**Application no: 22/02696/DISC**

**Location:** OS Parcels 3309 And 4319 Adjoining And North Of, Milton Road, Adderbury

## **Lead Local Flood Authority**

Objection

Appendix D

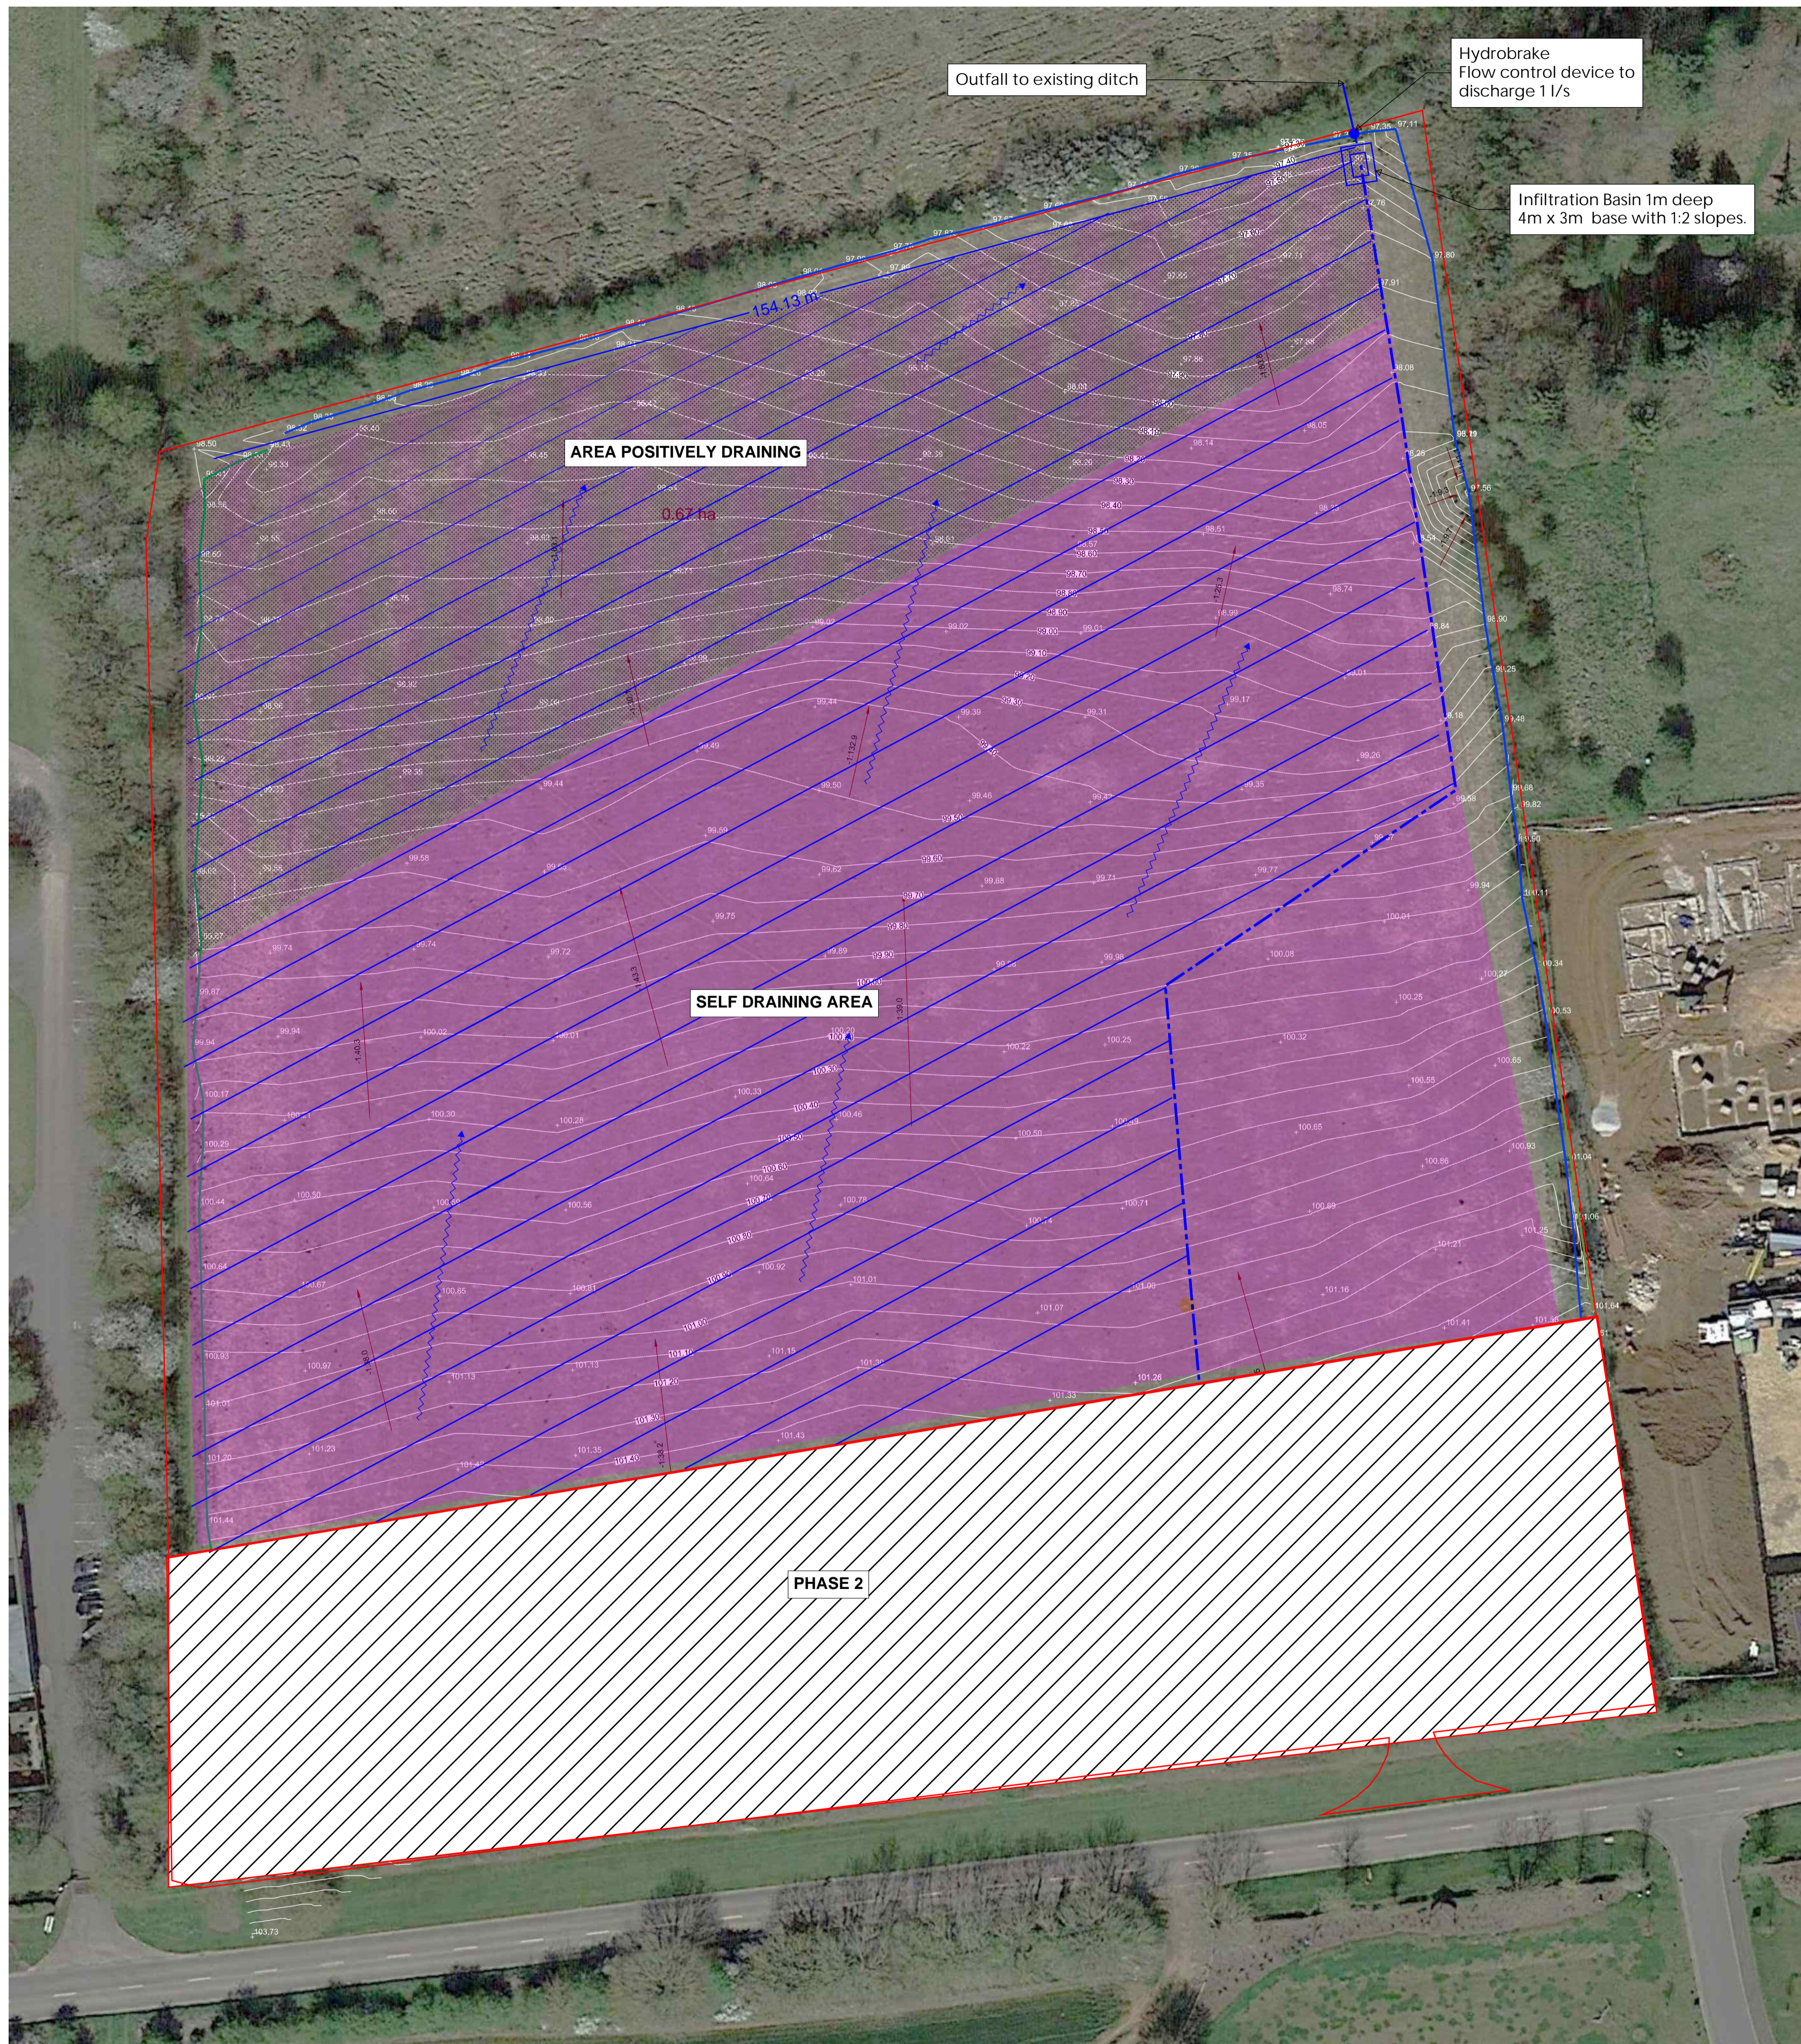
Detailed drainage drawing not provided. Provide invert and cover levels and length of infiltration trench. It should be made clear on the drawing and keyed up.

Provide catchment plan in order to understand the calculation.

Not provided

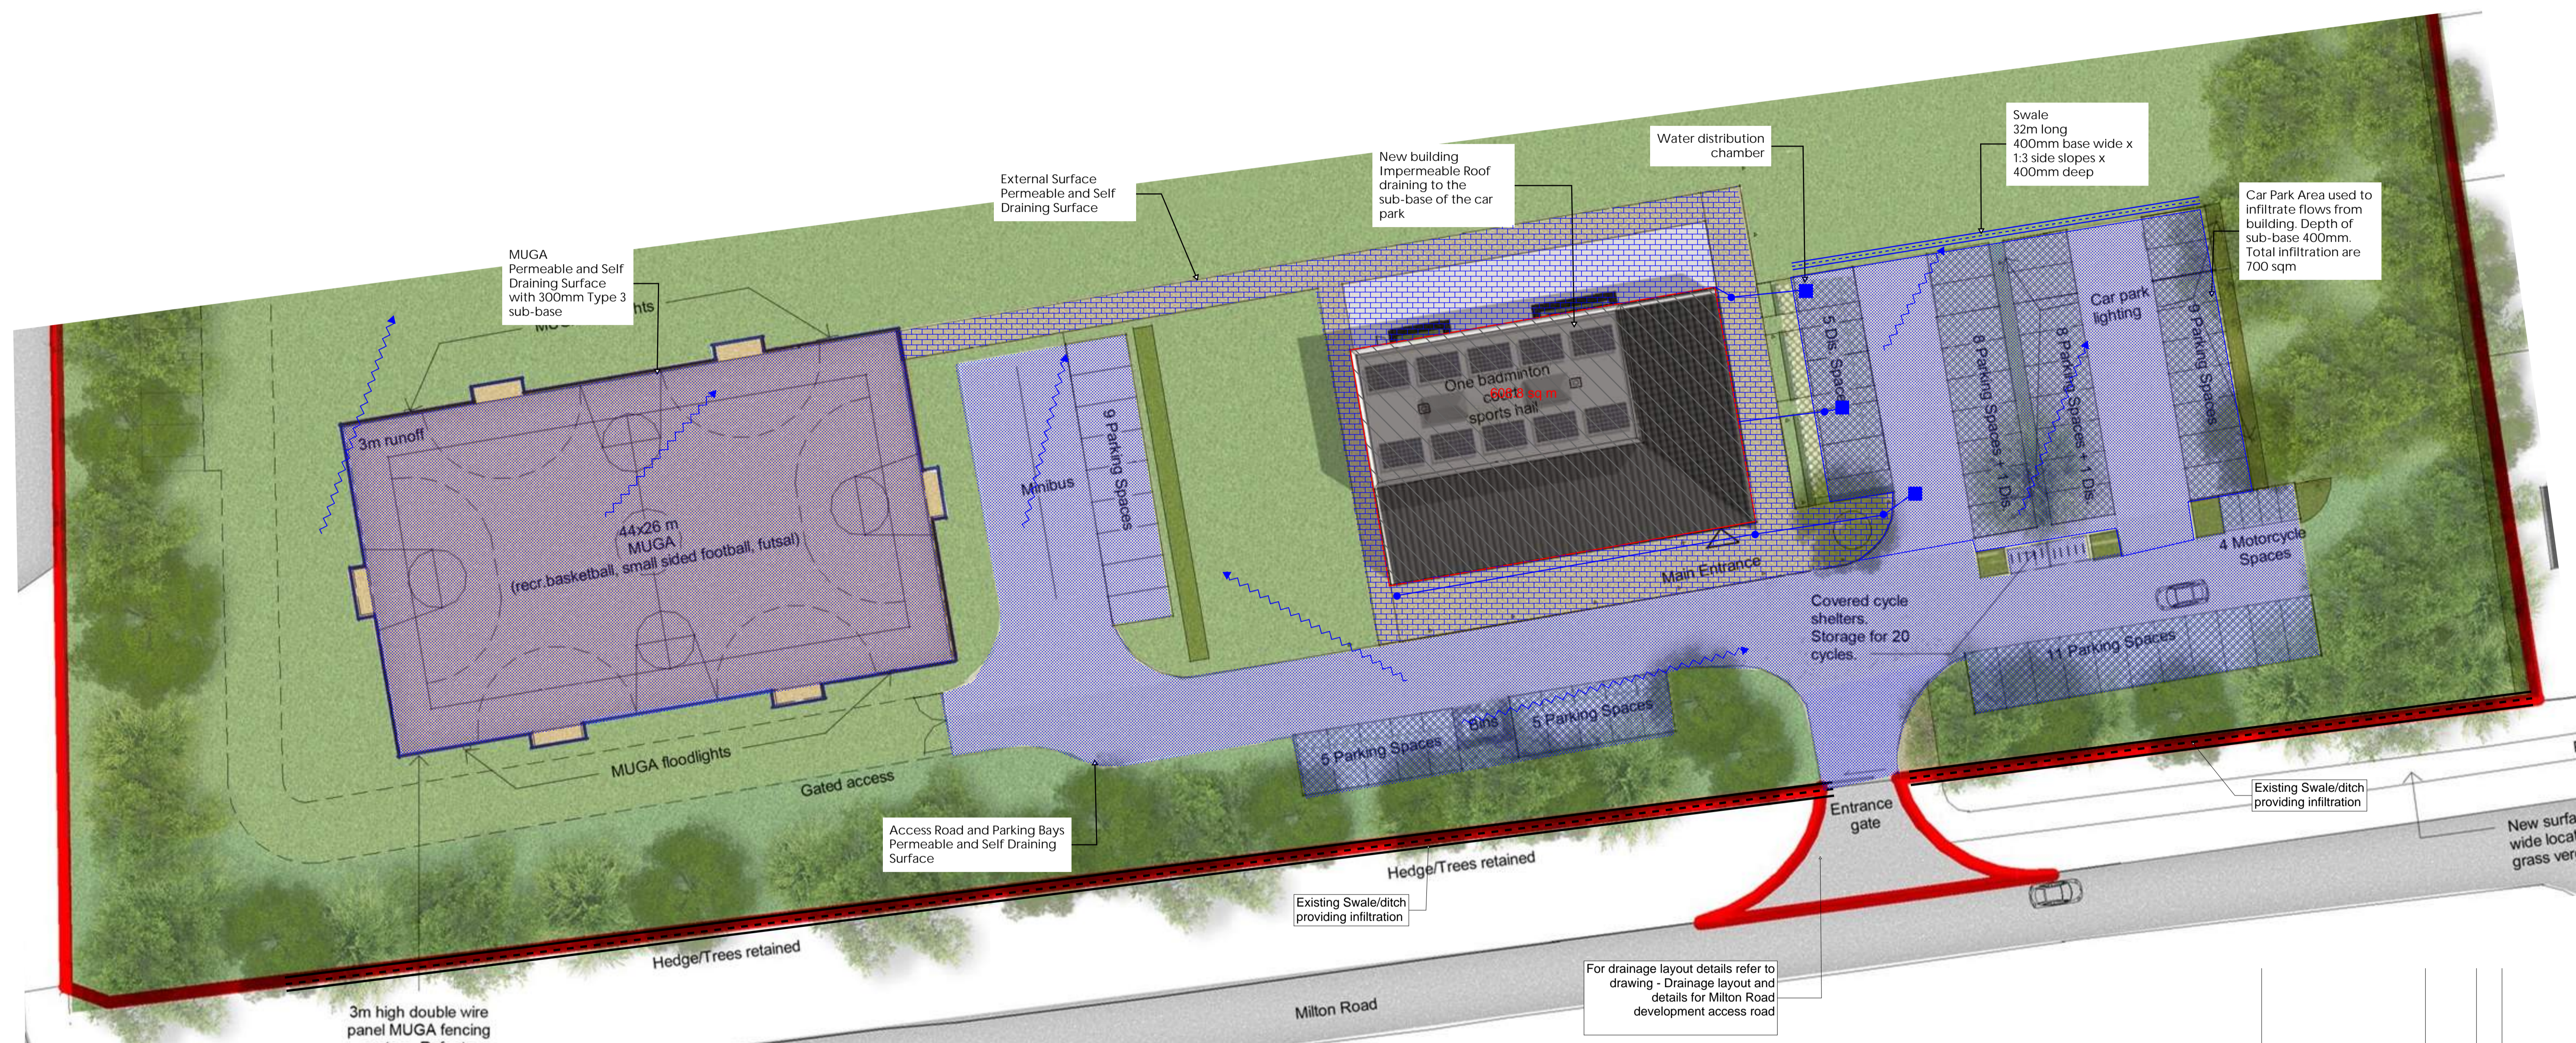
Infiltration trench not provided.

Drainage drawing is not detailed, the drawing does not show a key identifying all the SuDS features.

Provide surface water catchment plan, showing the extent of the different impermeable areas and stating the area.

Not provided
